**KIRKLEES METROPOLITAN COUNCIL
INVESTMENT & REGENERATION SERVICE**

DELEGATED DECISION TO DETERMINE PLANNING APPLICATIONS

Reference No:	2023/62/91110/E
Site Address:	76, Heator Lane, Upper Cumberworth, Huddersfield, HD8 8XJ
Description:	Erection of two storey side extension, detached garage with first floor above and external alterations following demolition of existing single storey side extension, detached garage and outbuilding
Recommending Officer:	Nicole Helliwell

Officer Report

76 HEATOR LANE UPPER CUMBERWORTH HD8 8XJ  
PROPOSED EXTENSION AND REPLACEMENT GARAGE  
PROPOSED ELEVATIONS

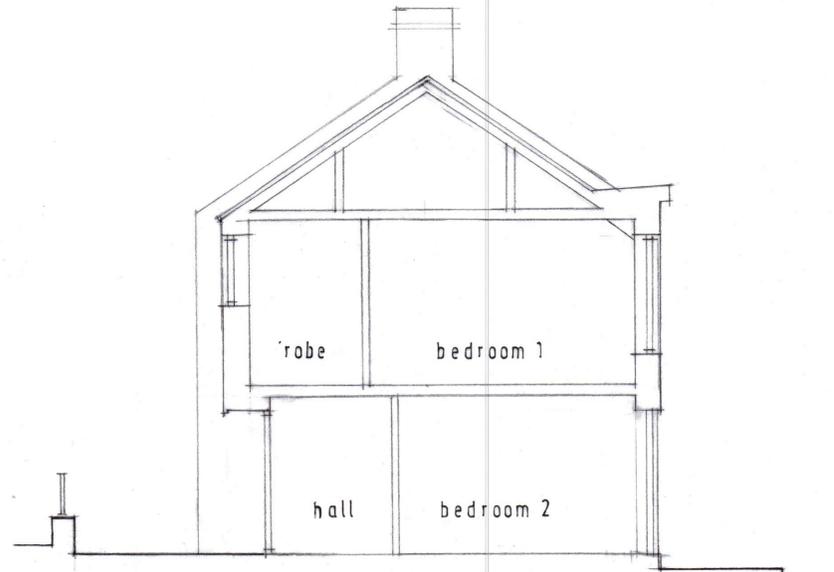
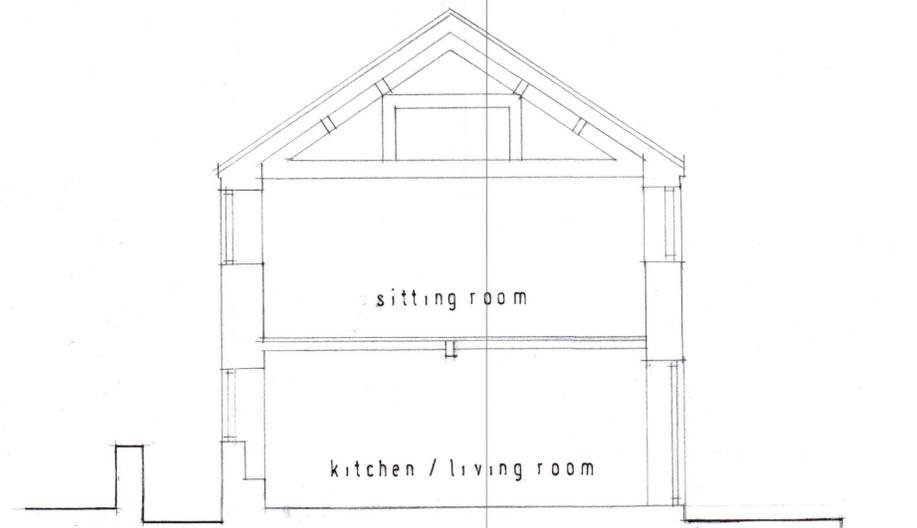
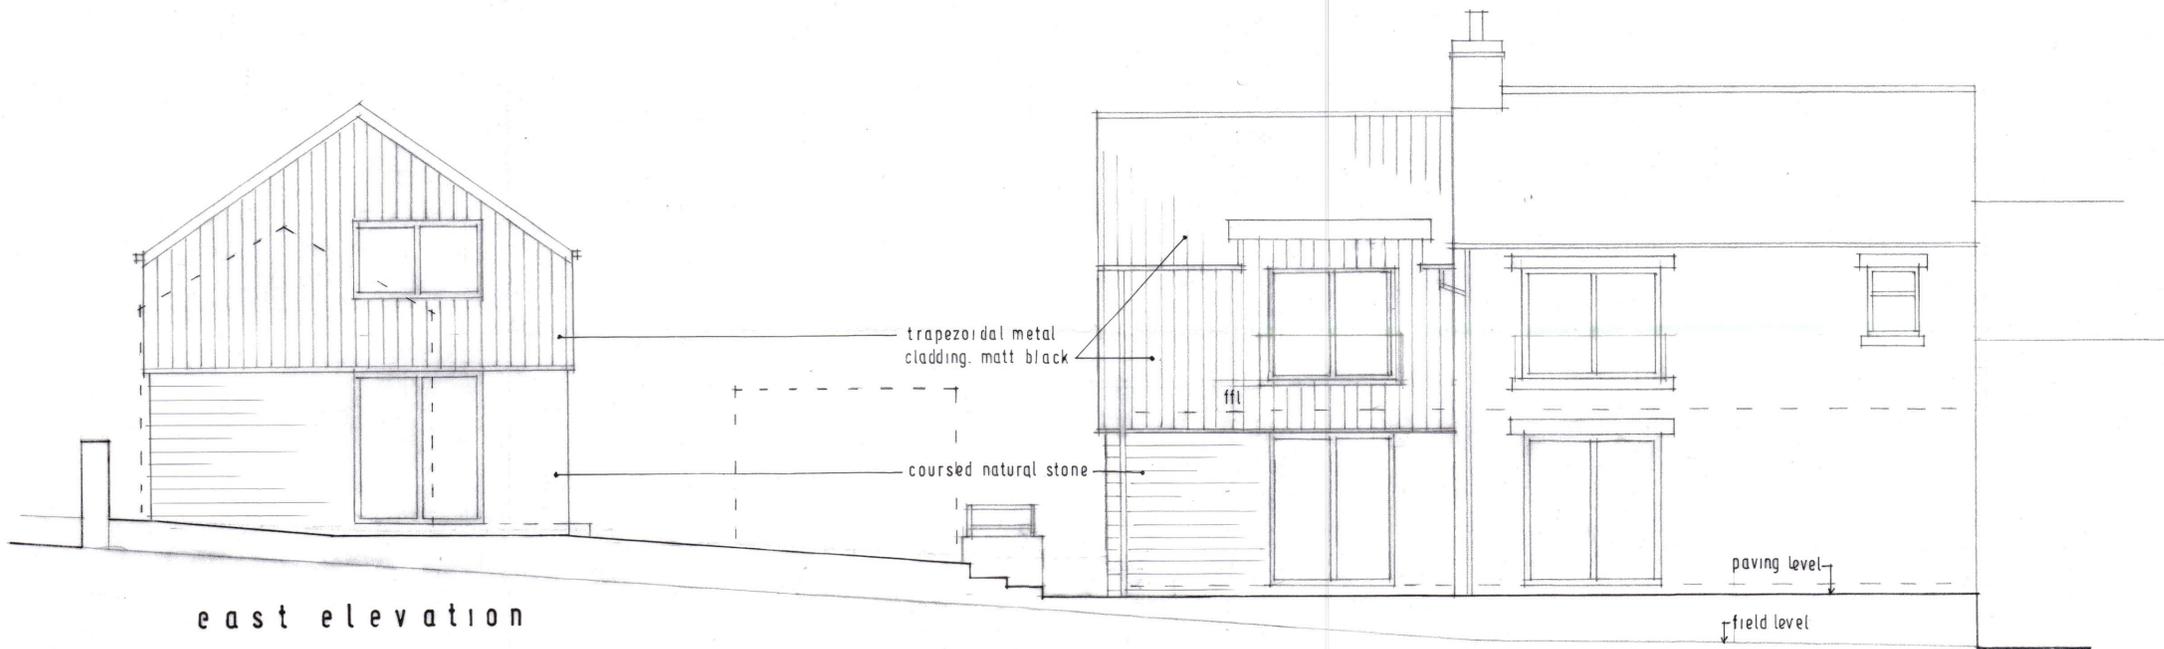
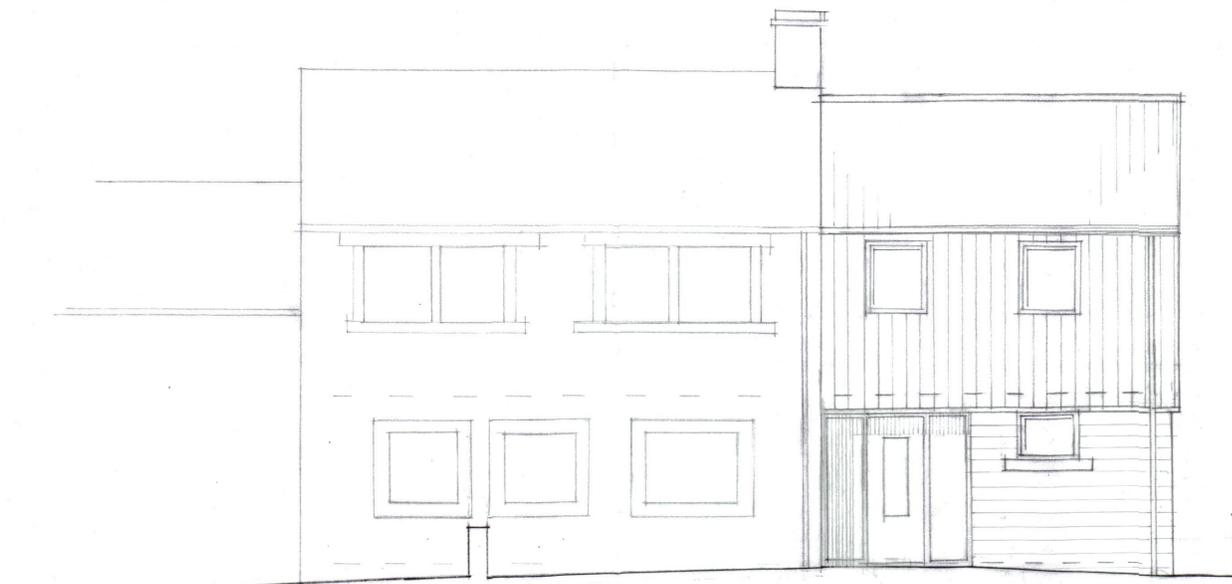
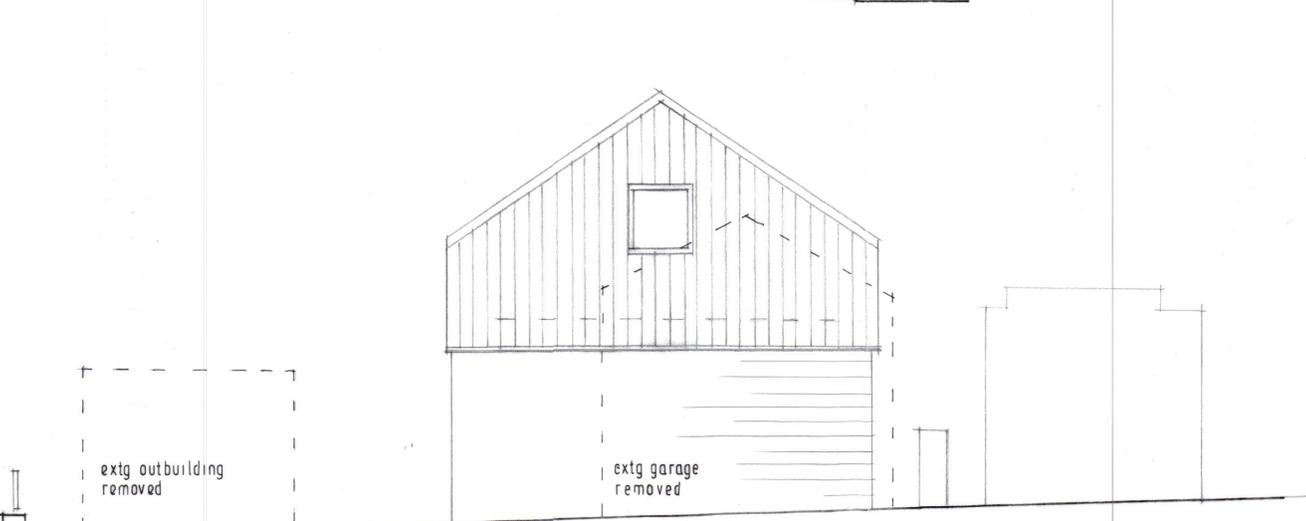
The proposed two storey extension would extend approximately 4.95m from the side elevation of the original dwellinghouse. The enlargement would be faced in natural coursed stone at ground floor level with trapezoidal matt black metal cladding at upper floor level and would incorporate a dual pitched roof finished in Black Trapezoidal metal cladding. It is considered that the material palette would be unsympathetic to the character of the surrounding area and would increase its prominence from public vantage points. Although the extension would be set back from the principal elevation, it would also have a bulky scale and would feature a high ridge line. Furthermore, due to its footprint, the extension would dominate the host property and would lack subservience. For these reasons, it is considered that the proposed two storey side extension would fail to respect the character and appearance of the host dwelling and surrounding street scene and therefore, the proposal cannot be supported in terms of visual amenity.

PROPOSED GARAGE DETAILS

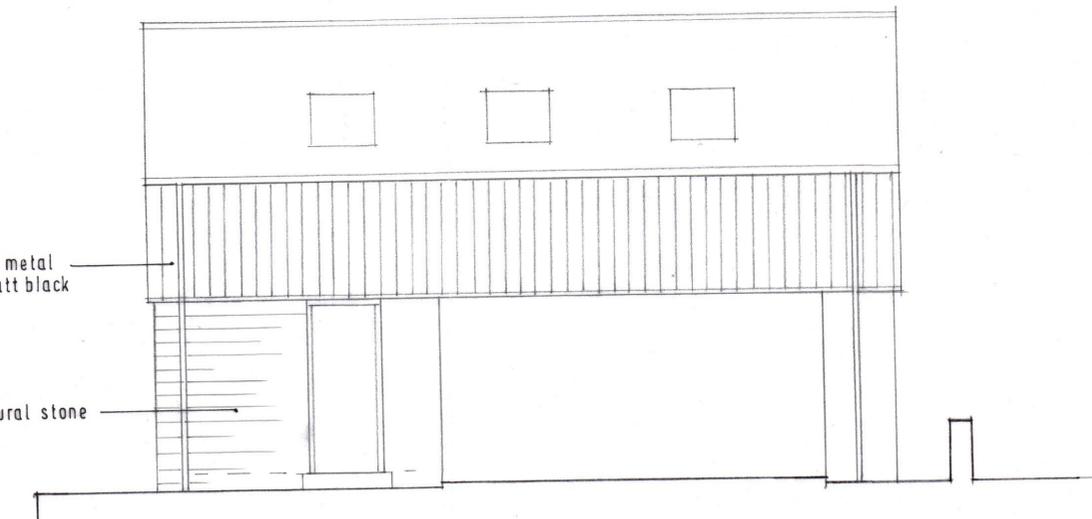
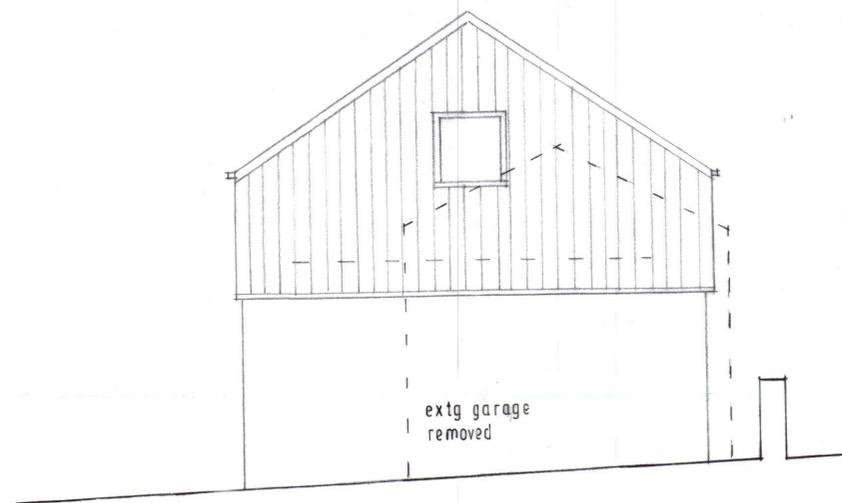
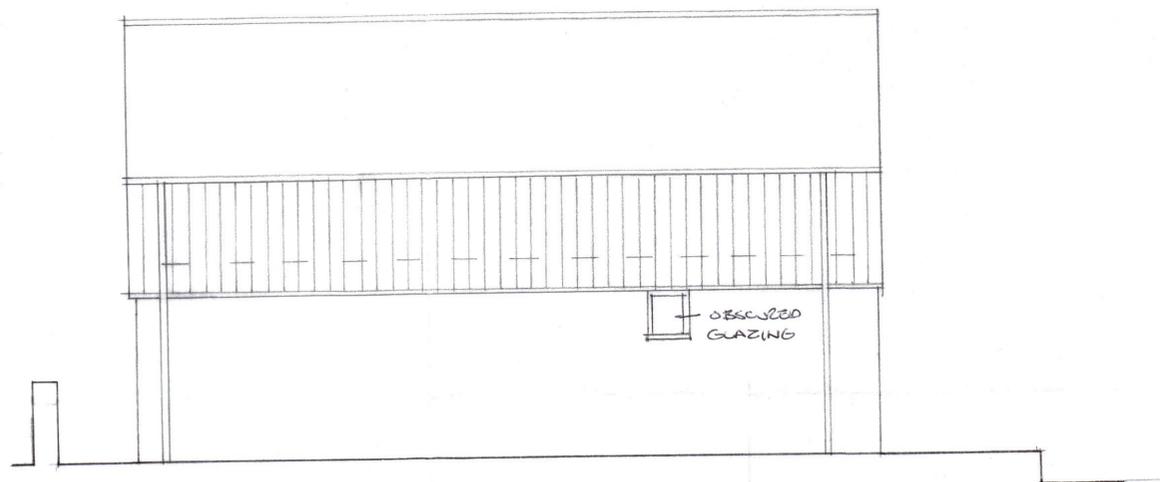
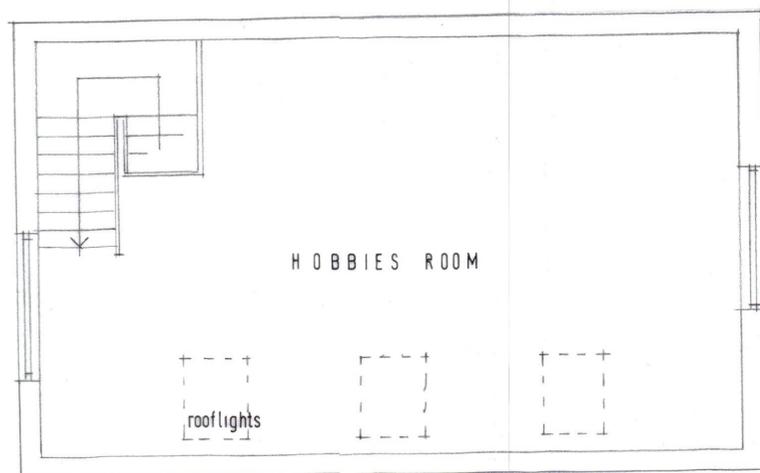
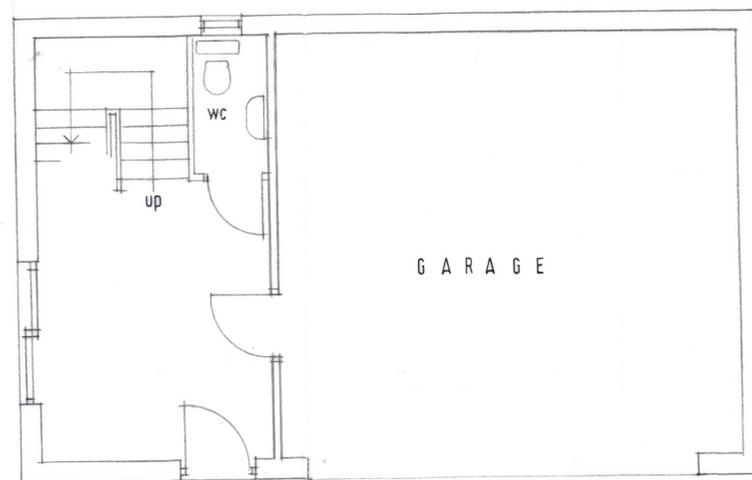
The detached garage would be two storey in height and would be located within the front curtilage of the dwellinghouse. The structure would have a length of approx. 9.5m, a depth of approx. 6m and a maximum height of approx. 6.1m due to changes in ground level. The garage would be faced in natural coursed stone at ground floor level with trapezoidal matt black metal cladding at upper floor level and would incorporate a dual pitched roof finished in Black Trapezoidal metal cladding. The structure would have an excessive scale and would be set forward of the original building line. Furthermore, due to its incongruous material palette, size and location, the garage would lack subservience and would appear highly prominent from public vantage points. On this basis, it is considered that the structure cannot be supported from a visual amenity perspective.
